Planning Application No: 3/2025/0540

Proposal: Proposed two-storey and single-storey extension to rear and insertion of dormers to front and rear roof slopes.

Location: Brooklands Longworth Road Billington BB7 9TS

sheet name:
Site Plans

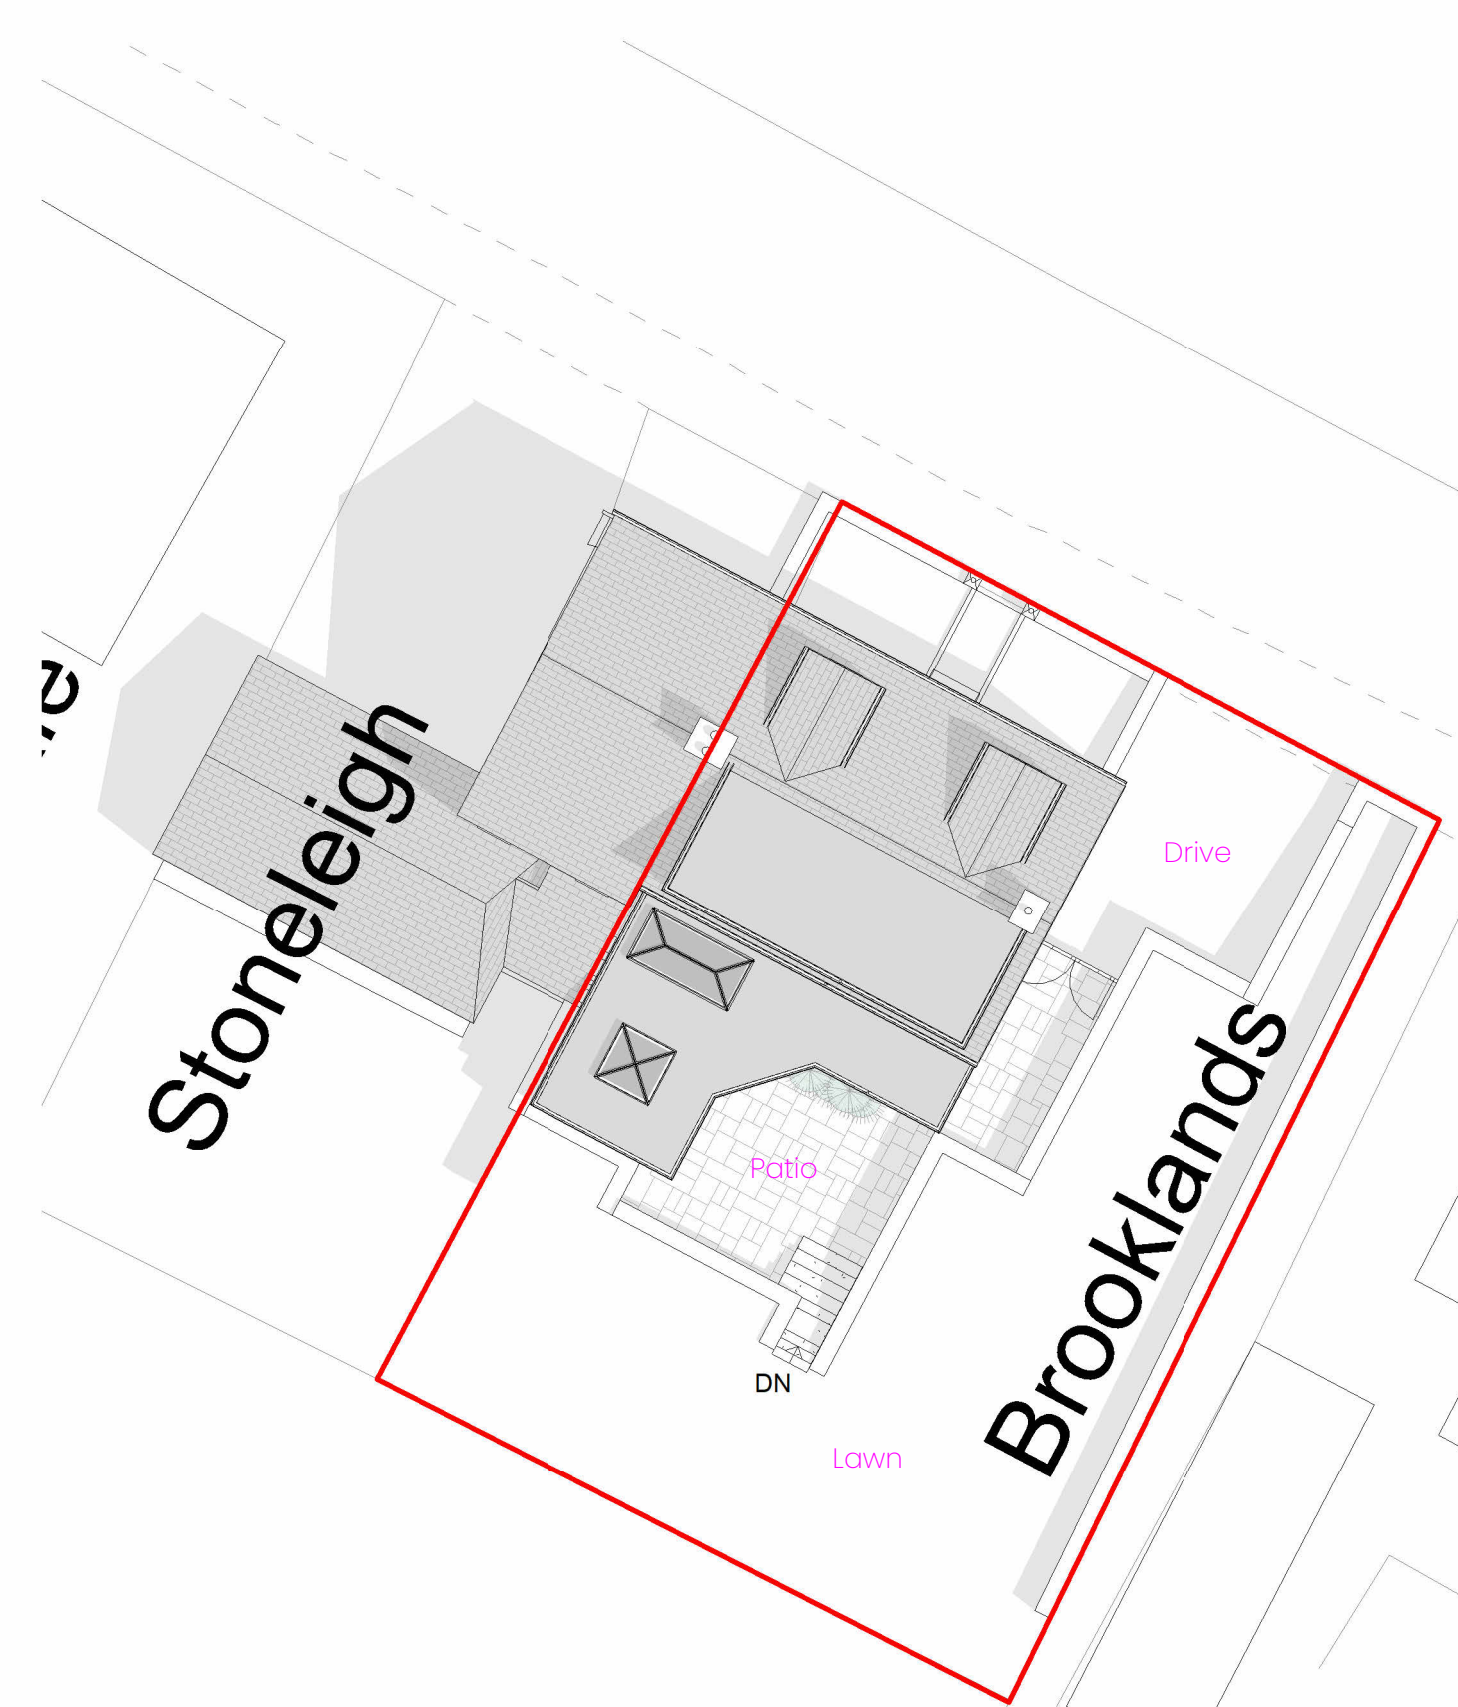
The proposed bedroom increases the number of bedrooms in the property from an existing three to a proposed fourth, therefore there is an increase in parking standard requirements to three parking spaces for this size of proposal.

There is no change required to the existing access, however, as there is a shortage of one parking space being proposed then a covered cycle store is required for 4 bicycles to promote sustainable forms of transport and aid social inclusion.

- Prior to the first occupation a secure, covered cycle store for 4 cycle spaces shall be provided. Reason: To promote sustainable forms of transport and aid social inclusion.
